RBBC Action Tracker - Note additional measures may be added depending on the ES.

Topic	Number	Concern	Summary of concern	GAL Comment	Status - Agreed subject to ES, Outstanding or Not agreed
Noise	Noise 1	Noise insulation - Over heating	With increasingly hot summers, and forecast increase in aircraft in the night period 23:00 to 07:00 concerns that the ventilation system provided to people will do nothing to cool the property in the summer months. TWG 4/5/22	The ventilators to be offered are not designed to meet overheating demands in all conditions, instead opening the windows would enable heat to be purged in domestic homes. There are a range of ventilators that can be turned up or down to ventilate noise sensitive rooms. It is envisaged that there would be one per noise sensitive room (living, dining, bedrooms). (TWG 4/5/22)	NOT AGREED - unclear from work to date how the noise insulation scheme will prevent properties from overheating in the summer, given inability to open the windows at night to cool the house down e.g. summer 2022, and issue only likely to get worse than at present.

Drawn date:
September 2023

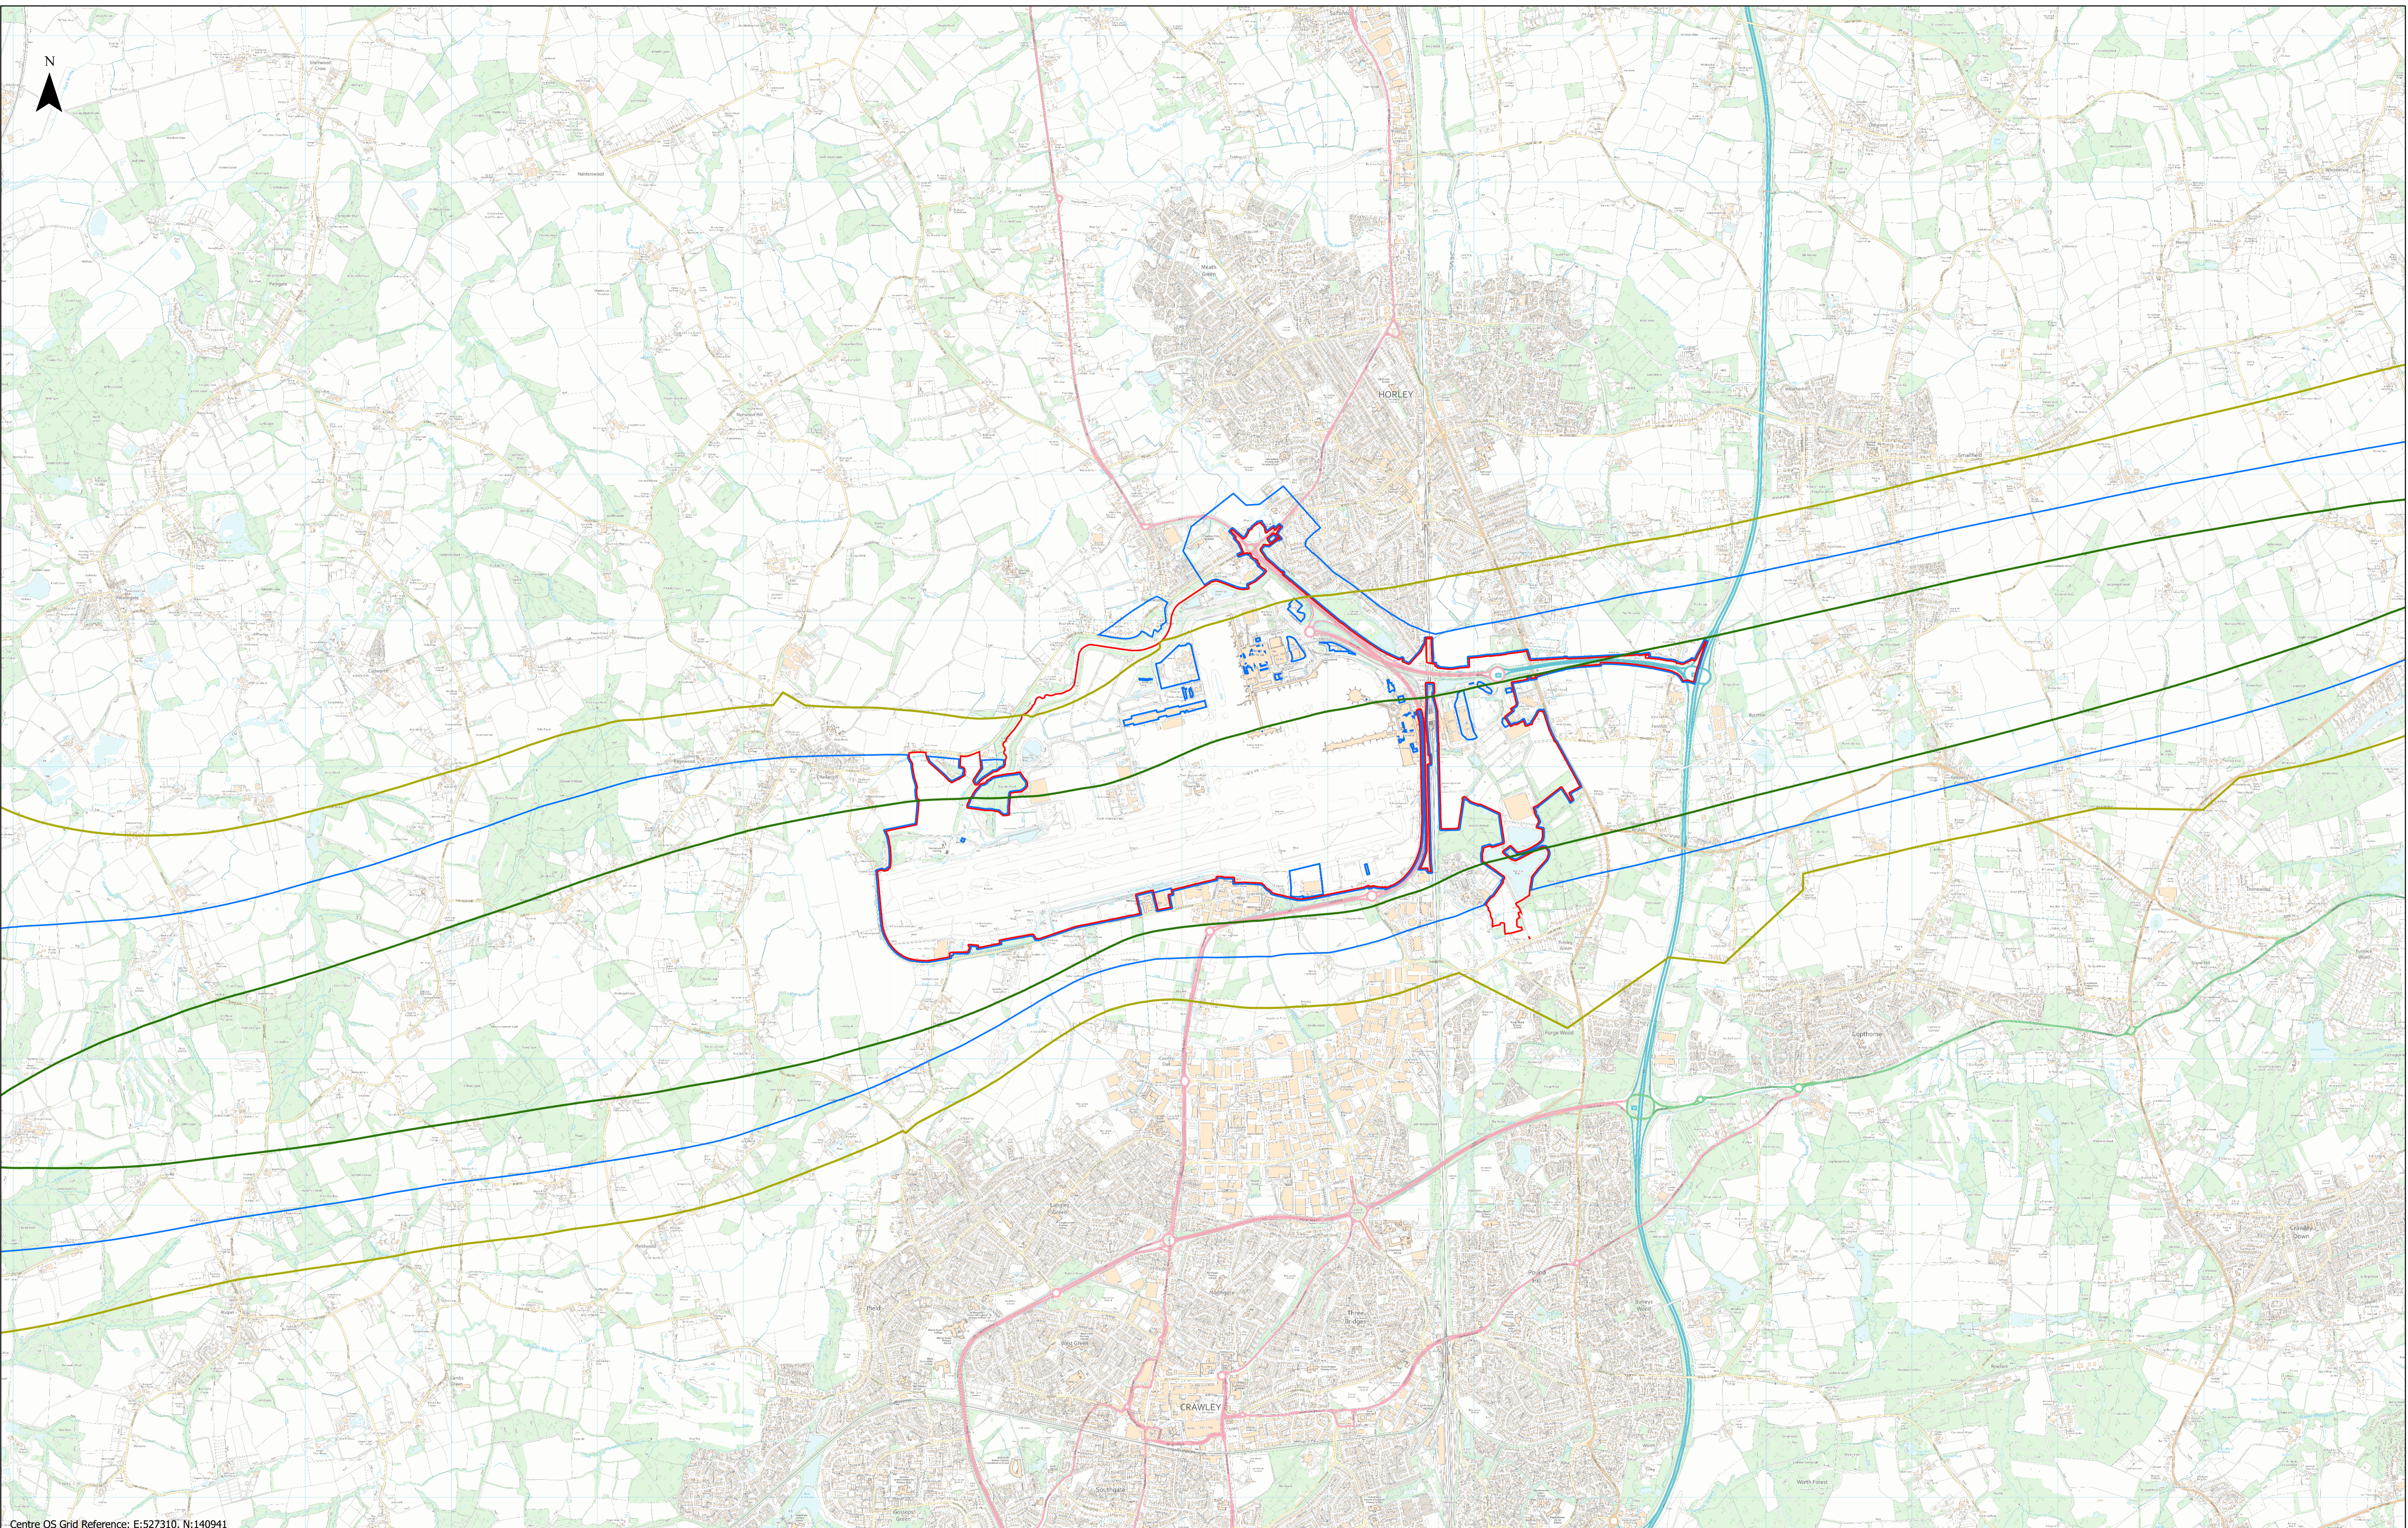
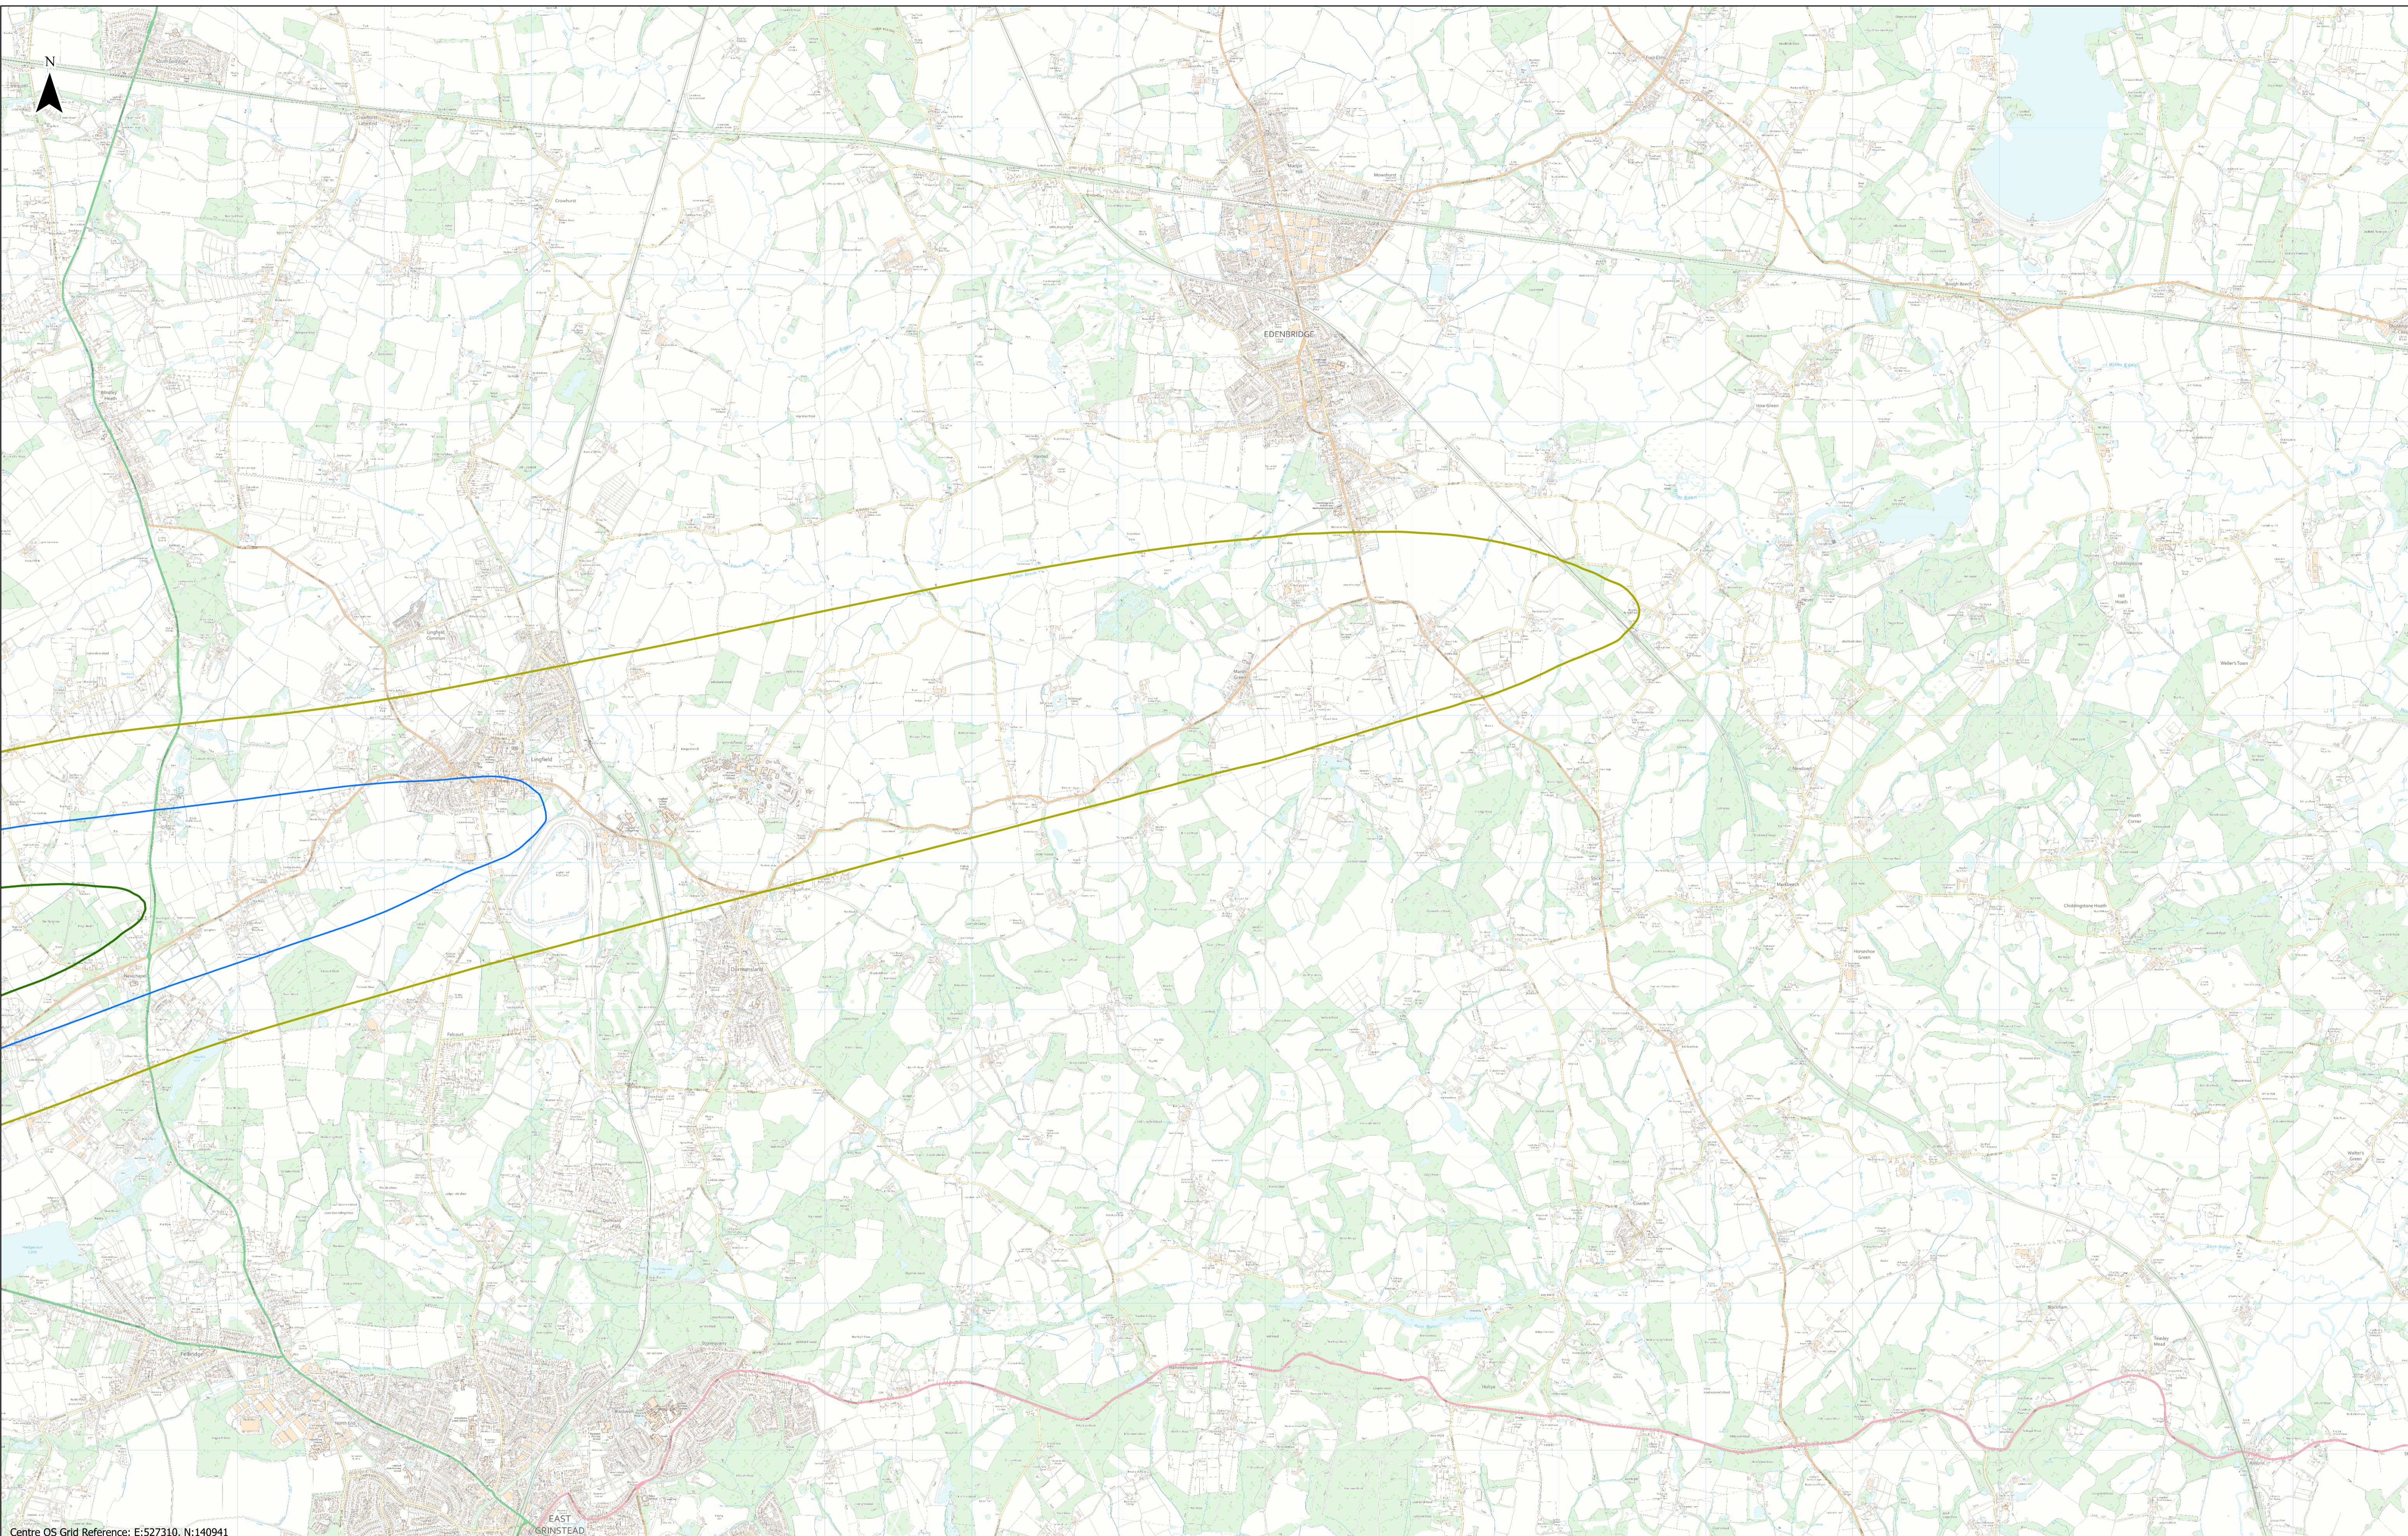
Noise	Noise 2	Noise insulation - levels and compensation	GAL is requested to review the scheme of mitigation and compensation and provide updated proposals having regard to the thresholds of qualifying for grants by applying good acoustic design and the policy of wherever possible improving an area as a result of NRP. This would still allow the airport to increase profitability and in part offset the social cost of the development. As part of this the noise exposure contours are to be produced with the airport operating in single mode to examine worst case daily exposure on a peak summer day and night (for Leq,T and N, above).	GAL has considered the thresholds for noise mitigation carefully and proposed to offer noise insulation at levels below the DfT guidance, i.e. making the scheme more generous than others. The two zone scheme also provides a higher level of mitigation to these worst affected which GAL feels is appropriate. We welcome views on the details of this scheme and will work with stakeholders to develop those details including through discussions at the Noise Envelope Group. We have provided 100% easterly and 100% westerly operations noise predictions for ground noise and operations noise predictions for air noise at the Community Representative Locations (See Appendix 14.2 Section 2, and discussion in para 14.9.67 to 14.9.84) however, these are provided for additional information and not used in the assessment of effects because the accepted criteria for judging those effects are the long-term average not the noise levels on a selection of the days when operations are only easterly or westerly. (August 2022)	Outstanding and subject to ES.

Noise	Noise 3	Noise insulation - scheme flexibility	In terms of the noise insulation scheme it is suggested that the outer zone offer may be more flexible so properties that either already have ventilation or are unable to have ventilation fitted can benefit it an alternate way.	It is expected that very few dwellings already have acoustic ventilation or unable to have it fitted. Details of the final Noise Insulation Scheme will be discussed with the Noise Topic Working Group. (Aug 2022)	Outstanding and subject to ES.
Noise	Noise 4	Noise - recommendation	To prevent and minimise ground noise and air noise impacts on communities to the North, any Northern Runway usage is limited to operations between 07:00 to 23:00 and is only used during the day for Chapter 3 aircraft or quieter.	The proposal is to use the Northern Runway between 06:00 and 23:00 hours to meet the requirements of the project. All aircraft at Gatwick are Chapter 3 or quieter. (Aug 2022)	Outstanding - restriction needs to be placed on the runway for Chapter 3 or quieter given night noise modelling is based on this assumption. Also time restriction needed unless main runway is out of use.
